MEMORANDUM

DATE: February 10, 2023
TO: Kacey Simon, Civil Plan Review
FROM: Emily Morgan, Senior Planner
RE: Kendall Subaru – *Civil Review 1* - (PA22-035; G23-0002)
CC: Chris Holland, Planning Manager
Ken McIntyre, PE, Assistant City Engineer

Drawing:  
**A1.1**  
 Job Number:  
**21c-4339**

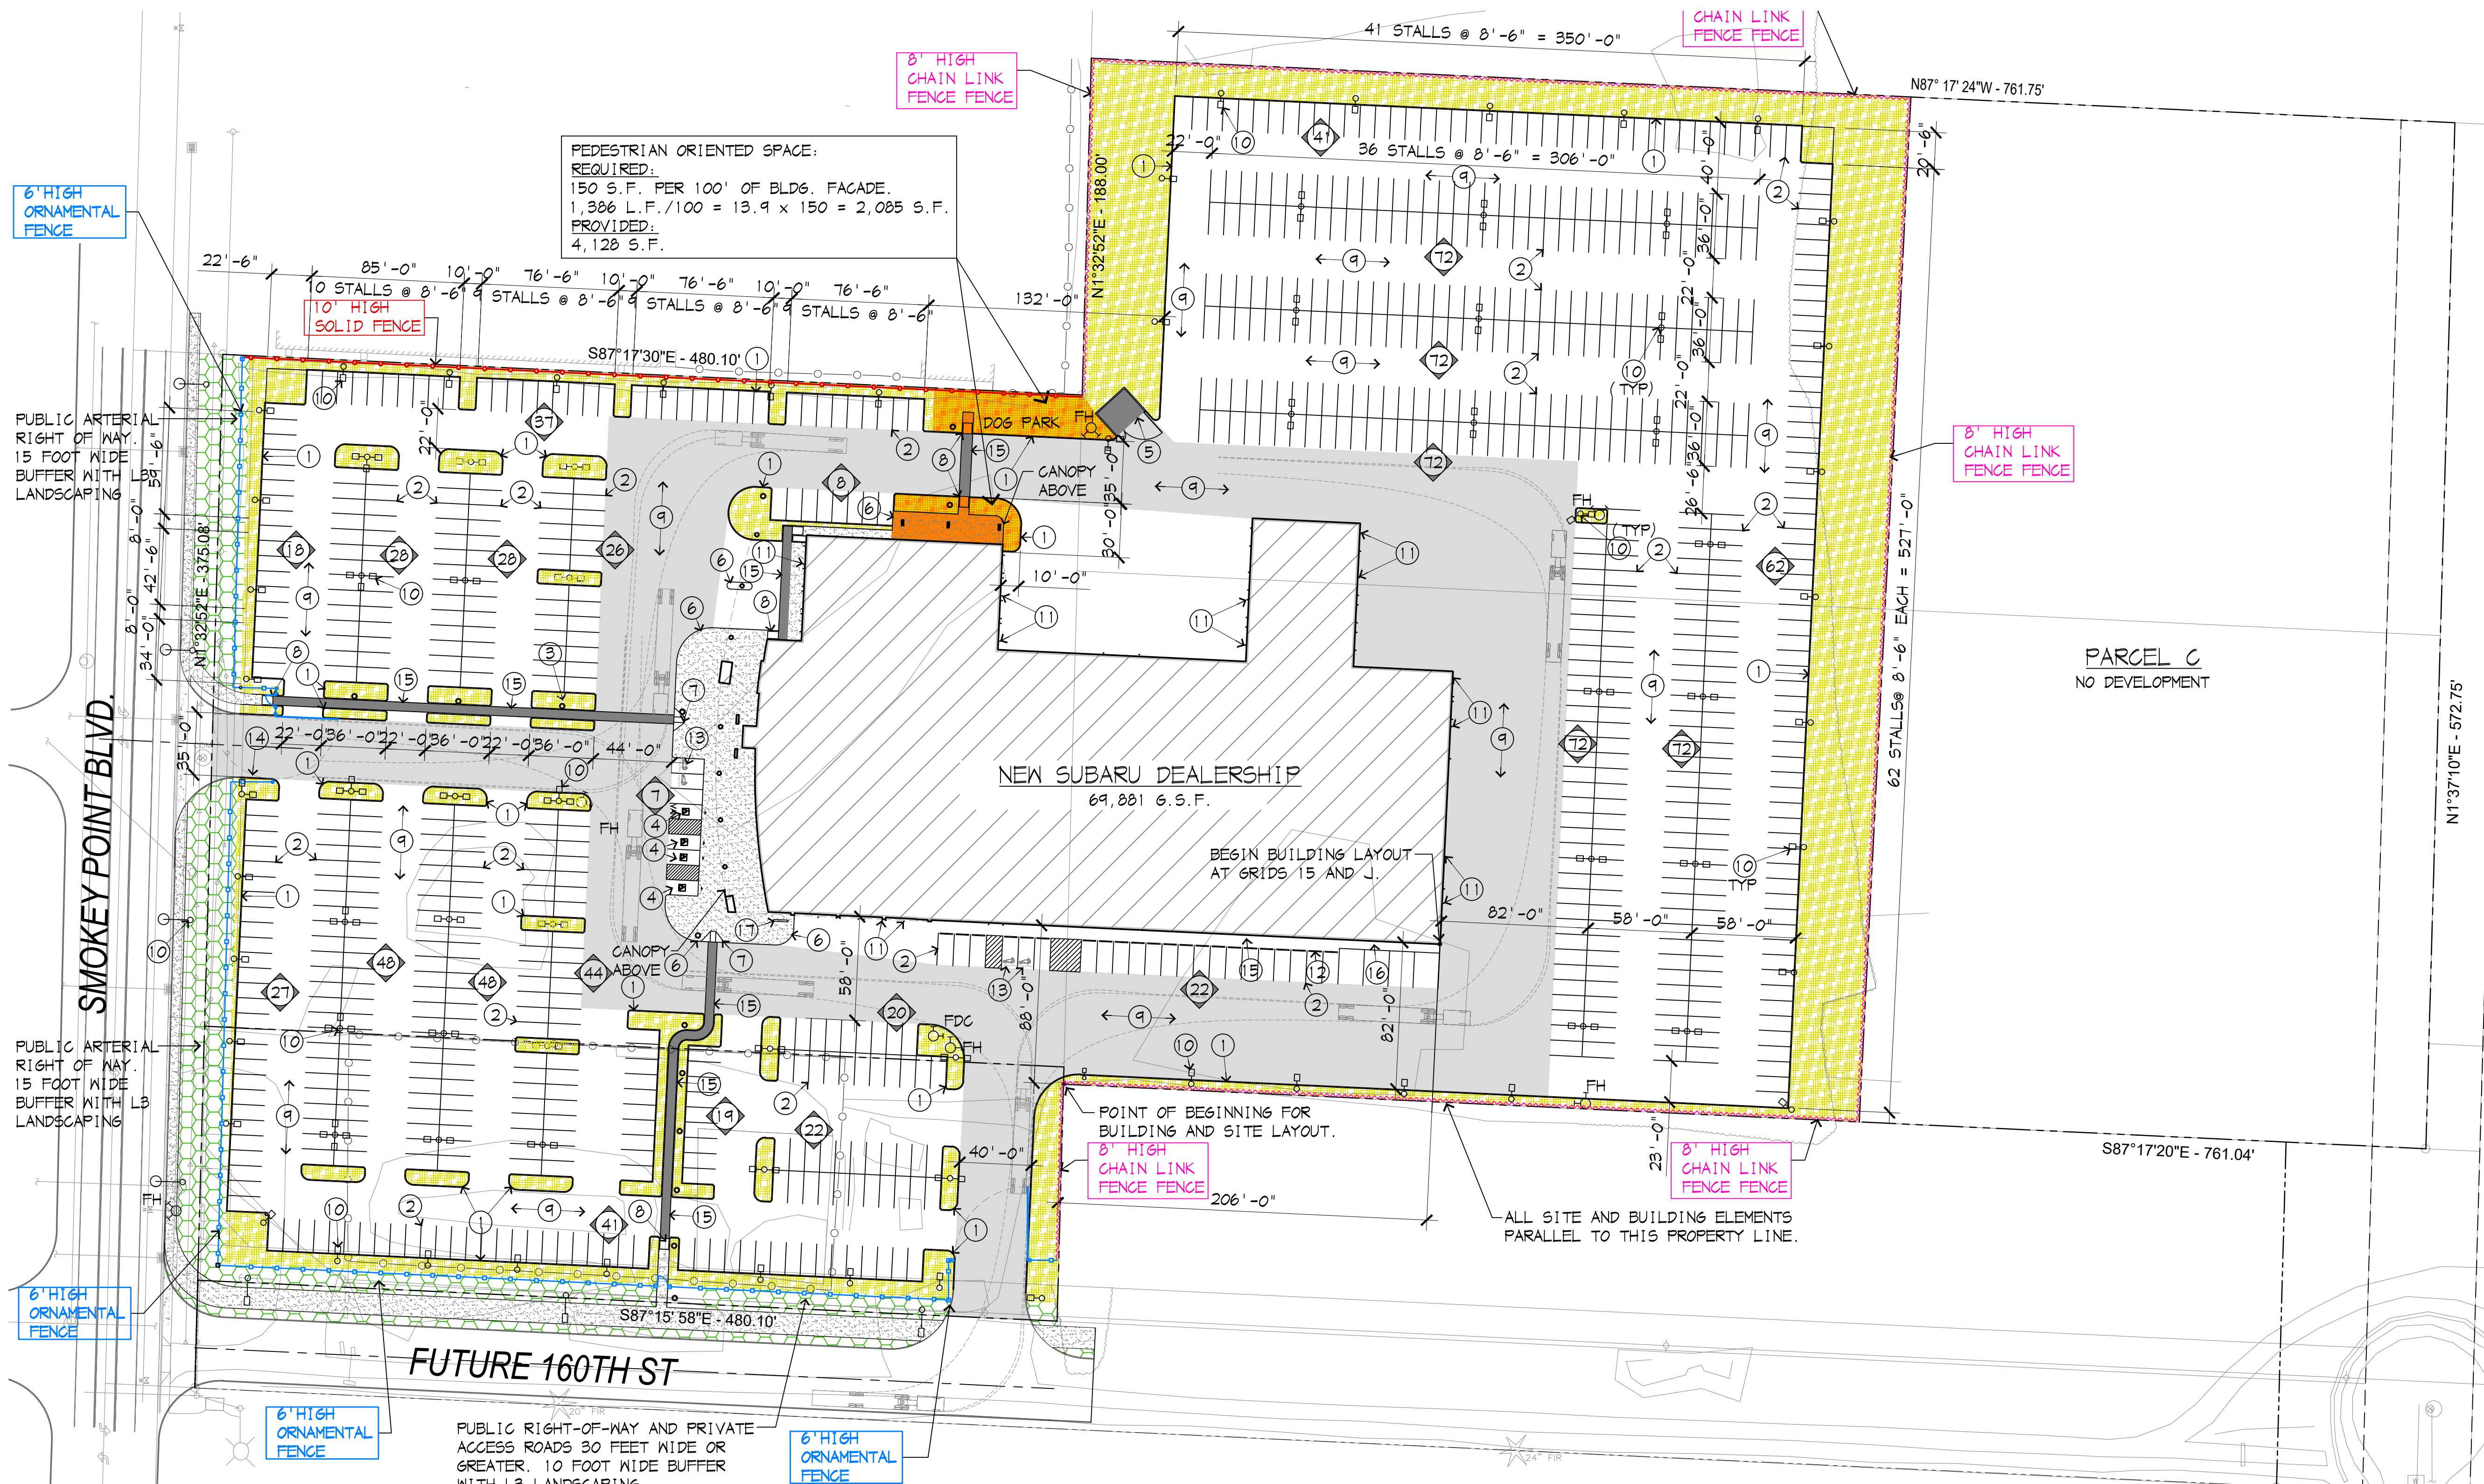
1. Pedestrian pathways that traverse a parking area or drive-aisle are required to be constructed with concrete pavers or decorative colored, or stamped concrete clearly denoting the pedestrian pathway. This detail shall be required to be provided on the civil construction plans.
2. Being as the proposed development includes more than 20 parking spaces, bicycle parking is required at 5% of the total number of required parking spaces per MMC 22C.130.030. Demonstrate compliance with MMC 22C.130.060 by including the calculations and location of bicycle parking.
